TOWN AND COUNTRY PLANNING ACT 1990

FULL

Reference:	H16-0727-23	Date of Decision:	10th October 2023
Applicant:	Mr D Roberts 75 Bourne Road Spalding Lincolnshire PE11 1JR		
Location:	75 Bourne Road Spalding		
Description:	Removal of existing conservatory and replace with one and half storey extension & erection of carport (retrospective)

A3 Drg No : **3289 - 05**

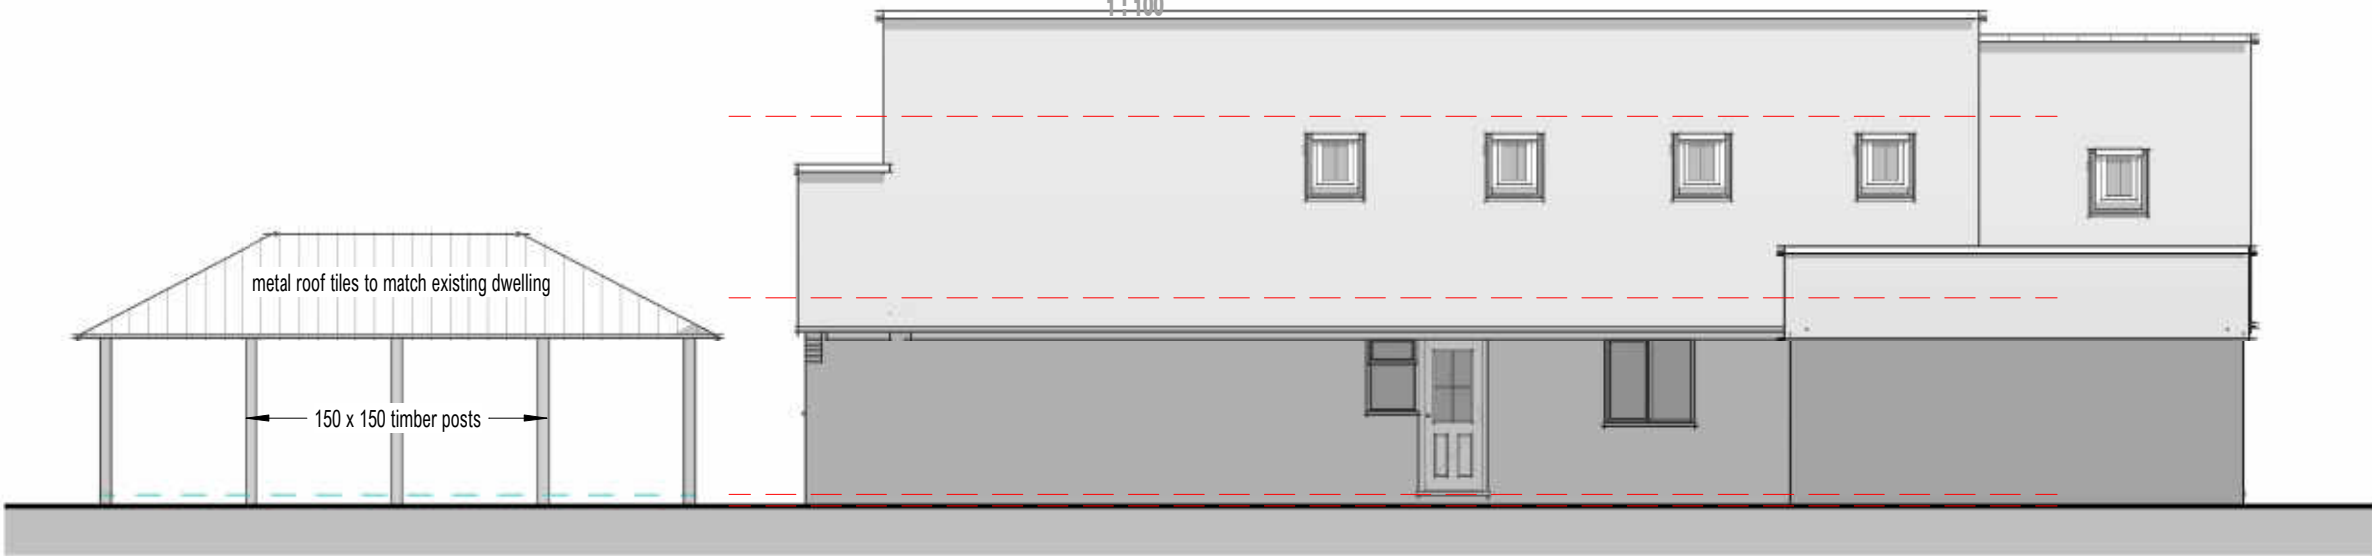
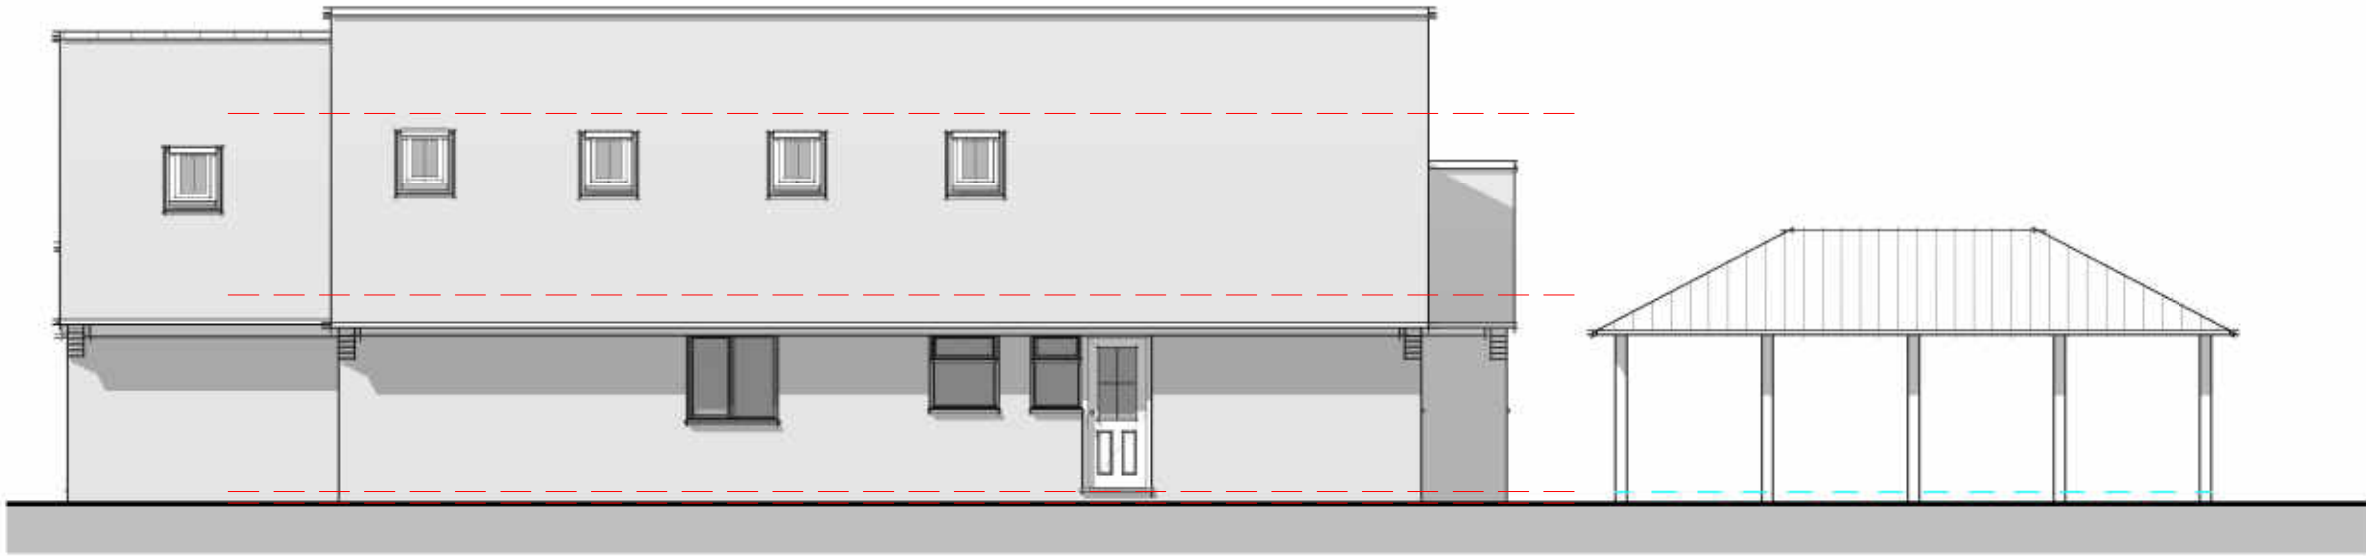
- 1 It is considered that the proposed carport, by virtue of its siting and scale, would significantly reduce the levels of light reaching the adjacent dwelling (73C/D Bourne Road). As this window is the sole window to a habitable room, the impacts of this overshadowing would be severe and unacceptable.

- 2 It is considered that the proposed carport would represent an incongruous form of development, severely at odds with the character of the area. Carports are not a common feature of the area, with the timber material proposed being similarly uncommon. The impact of this alien feature is exacerbated by its significant scale, drawing further attention to the carport and thus further impacting the character of the area. It is therefore considered that the proposal fails to conform to the principles of good design outlined with the National Design Guide, 2021.

- 3 It is considered that the scale of the proposed carport is disproportionate to the existing built form of the area as well as the host dwelling. The height of the carport is out of proportion to the established height of 75 Bourne Road, resulting in the carport becoming visually dominant and harmful to the street scene.
